RE: Sunport Cell Phone Parking Lot

2200 Sunport Blvd. SE Grading & Drainage Plans

Engineer's Stamp Date: 1/25/2023 Hydrology File: M16D024C

RE: TR A-1 Plat of TRS A-1 & A-2 Sunport Municipal Addn. (M16D024C) 2200 Sunport Blvd. SE **Grading and Drainage Plan Engineers Stamp Date 8/26/2022**

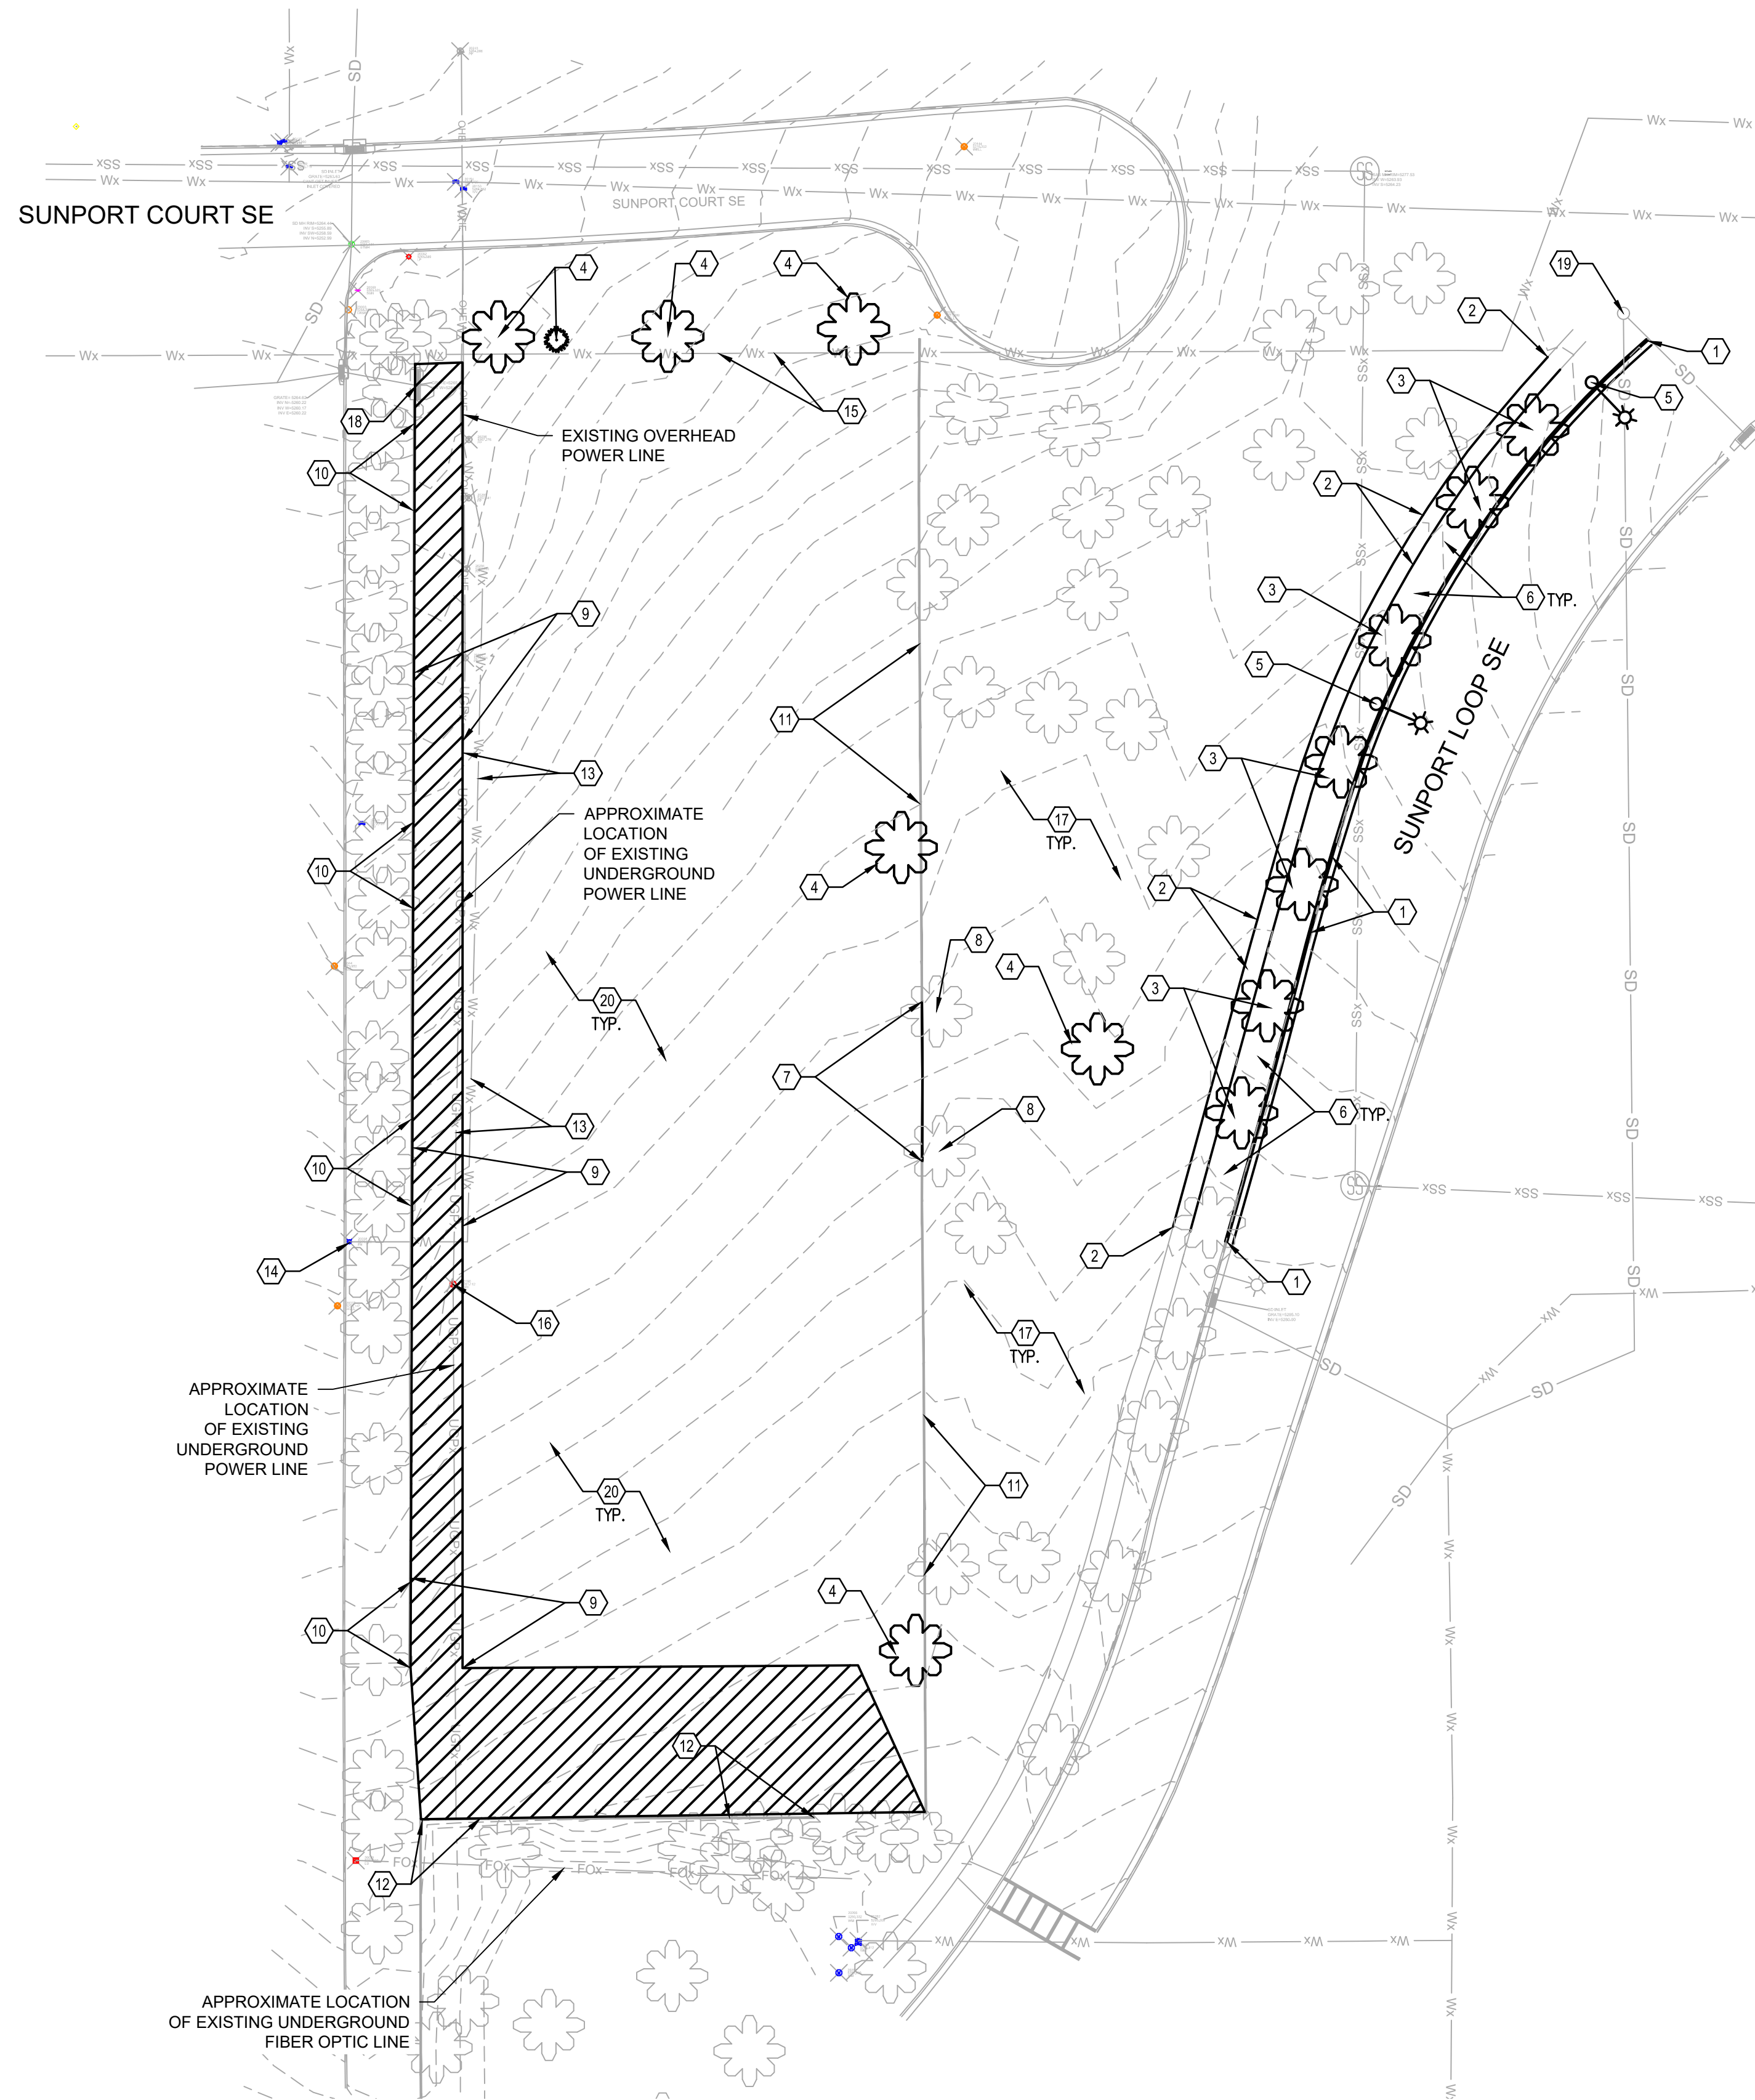
1) How many mature trees will be taken out as part of the deceleration lane and entrance construction. It does not appear that all existing three are shown on the plan. Eight (8) mature trees will be taking out as part of the deceleration lane and entrance. Trees will be replace, see sheet C-101 & LP-101 for demolition plan and landscape planting plan.

There is an existing area with buckled sidewalk just north of the start of deceleration lane.

Concur, construction note added to demolition plan.
